Date: 21 March 2024

Planning Act 2008 (as amended) – Section 51

Application by Mona Offshore Wind Limited for an Order Granting Development Consent for the Mona Offshore Wind Farm

Advice following issue of decision to accept the application for examination

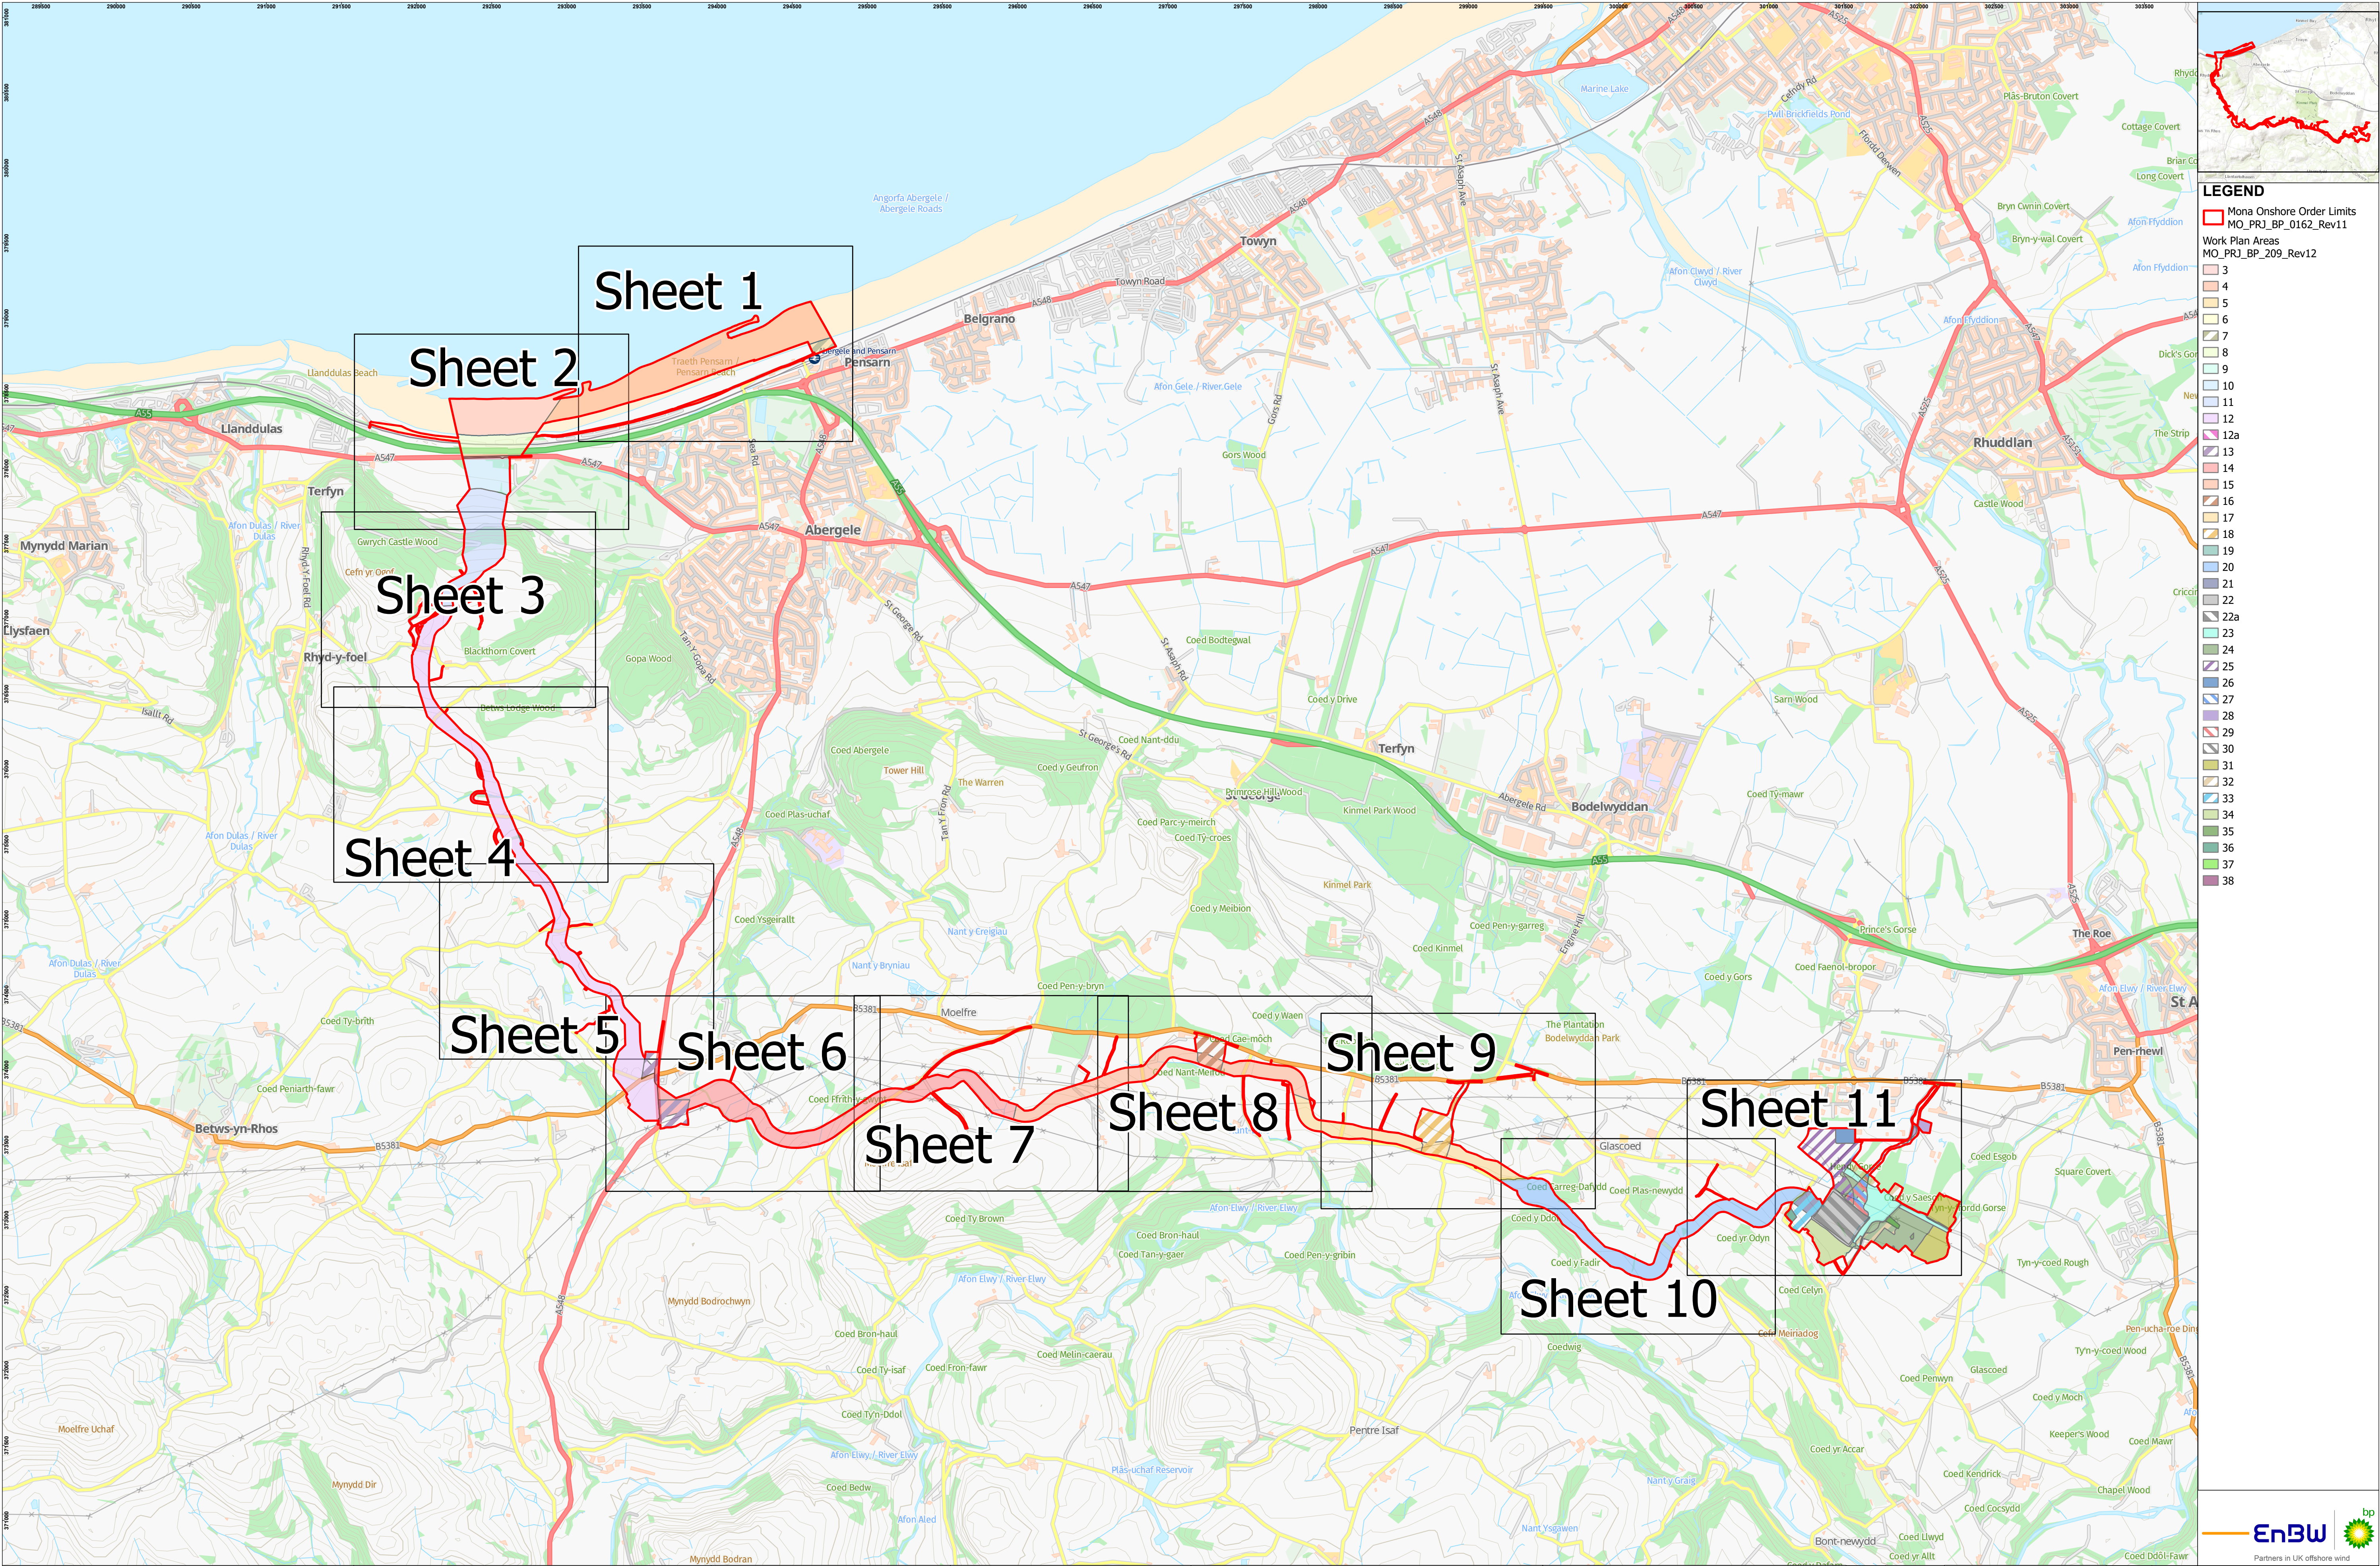
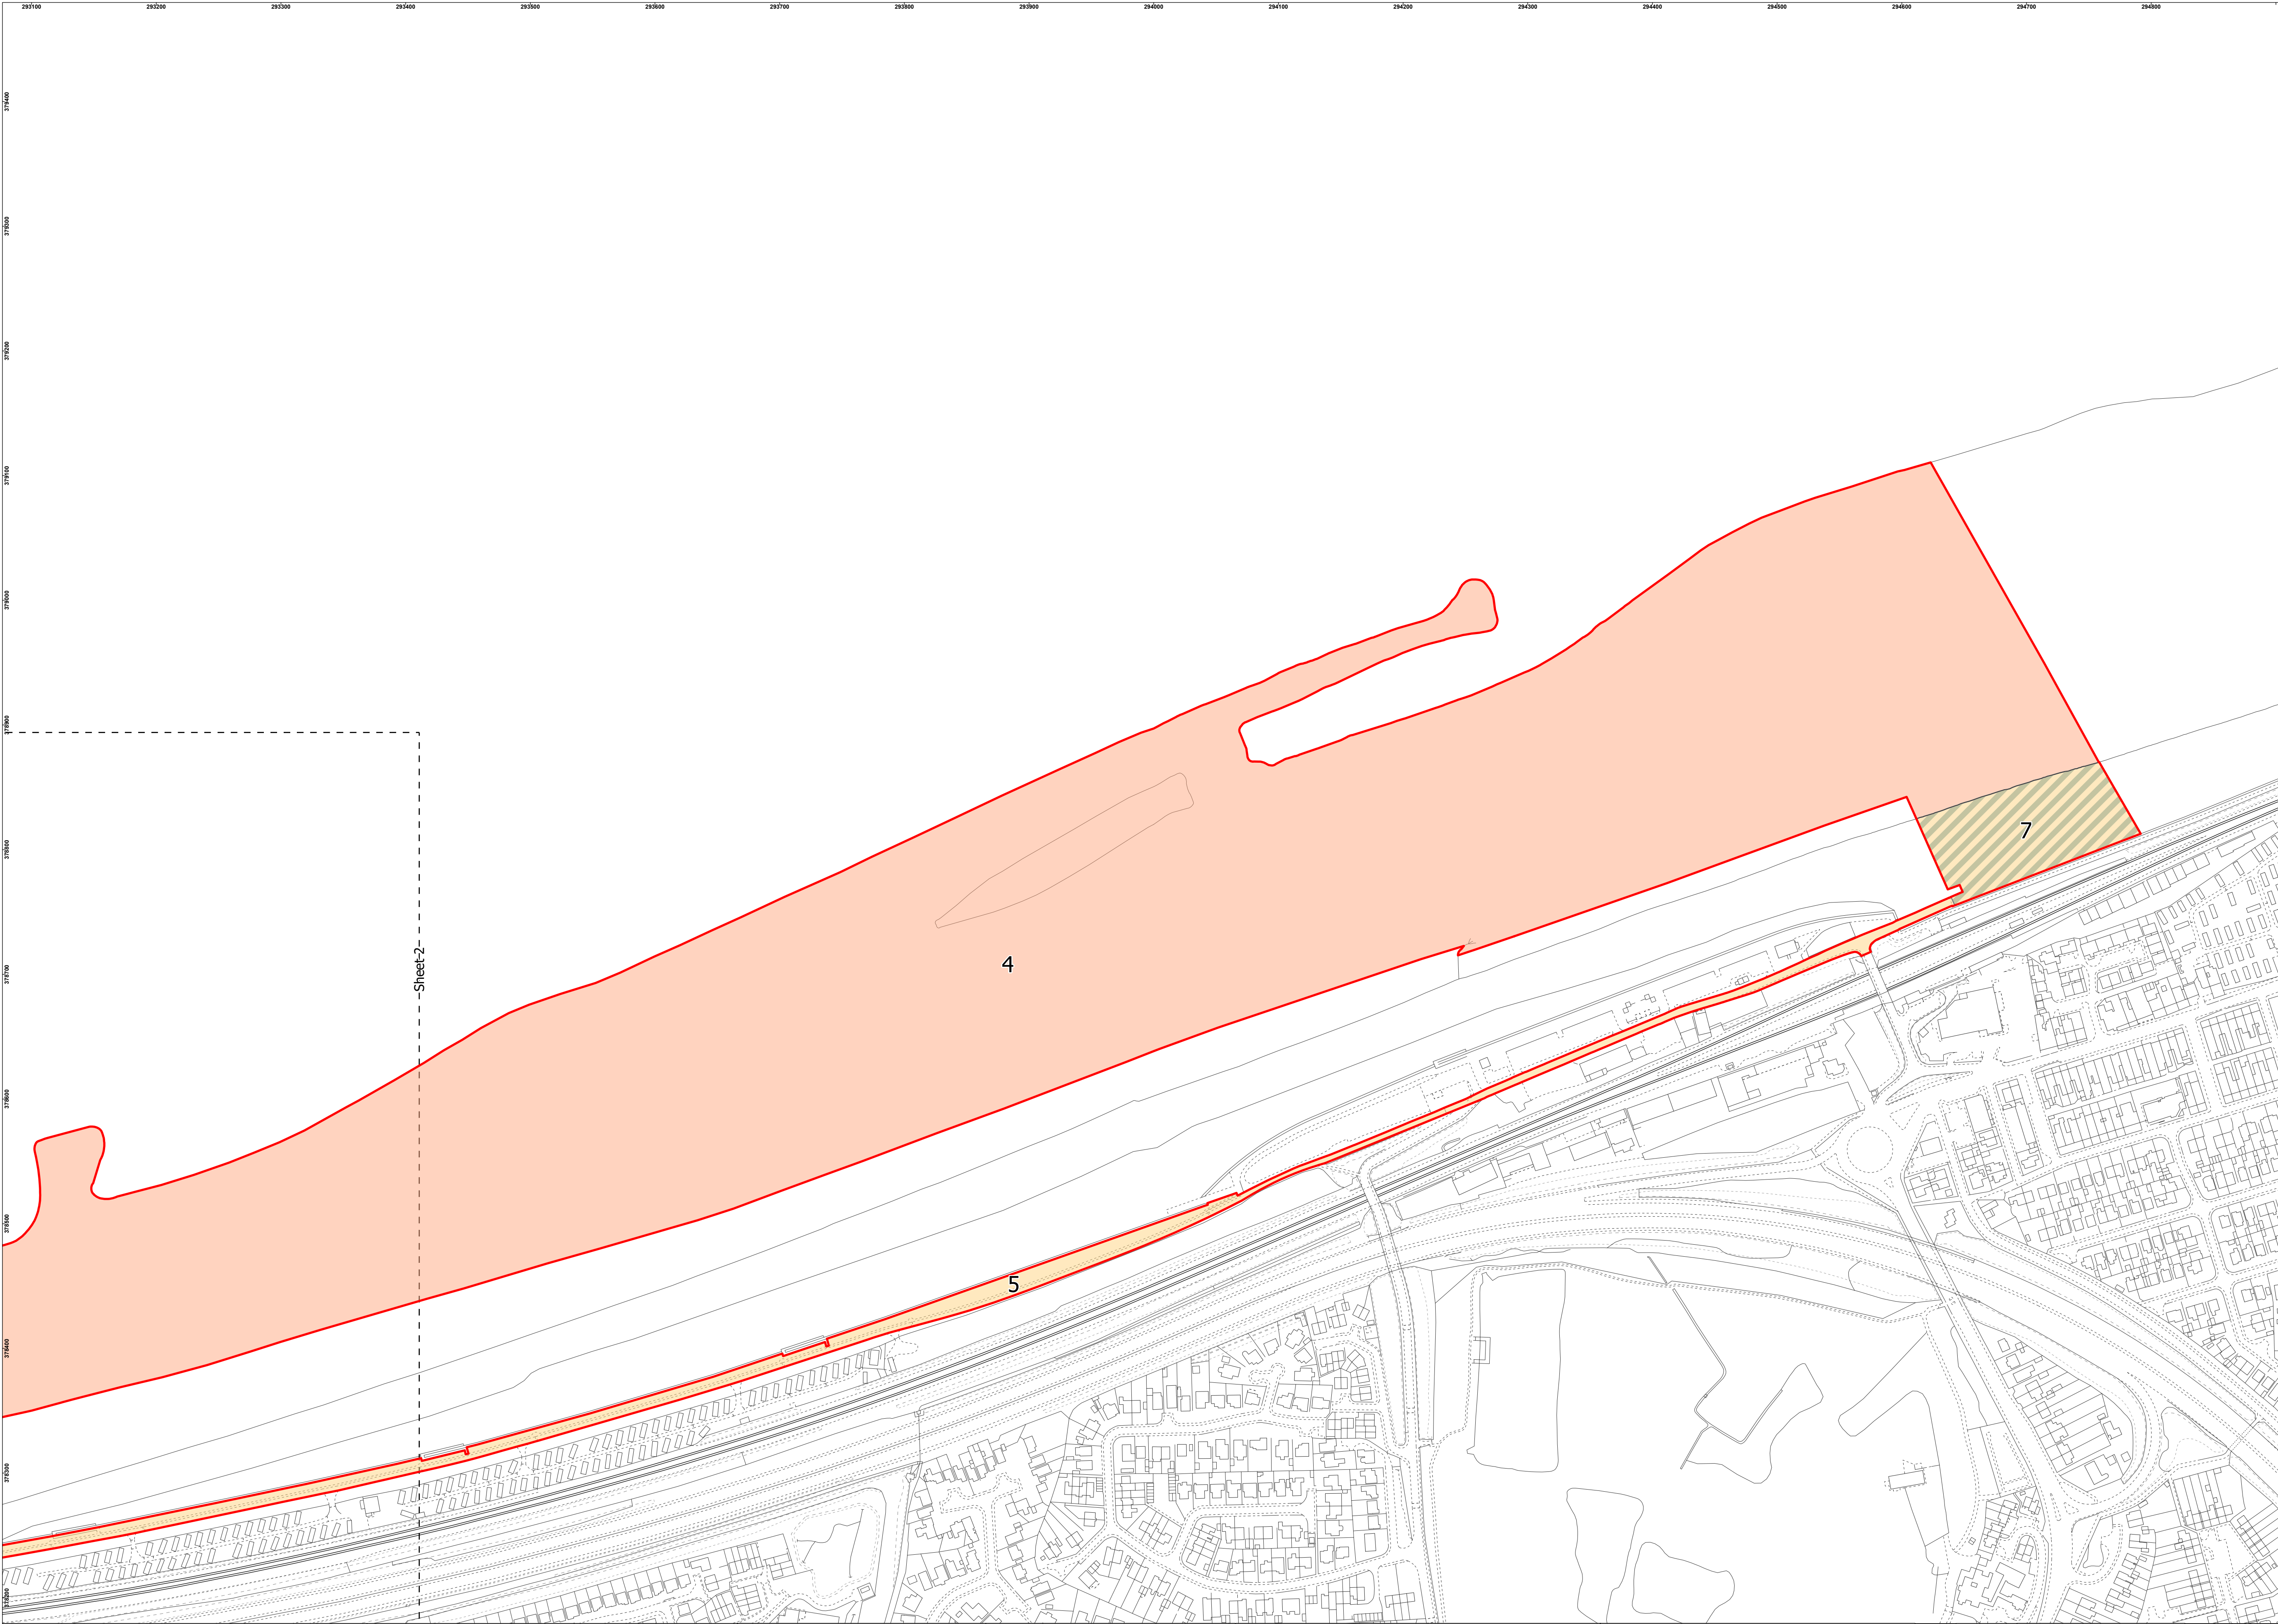
dDCO Schedule 1: Work No. 9 appears to erroneously refer to a connection between Work Nos. 3 and 10; it appears from the Works Plan that it should refer to a connection between Work Nos. 8 and 10. It would be helpful if this could be clarified.
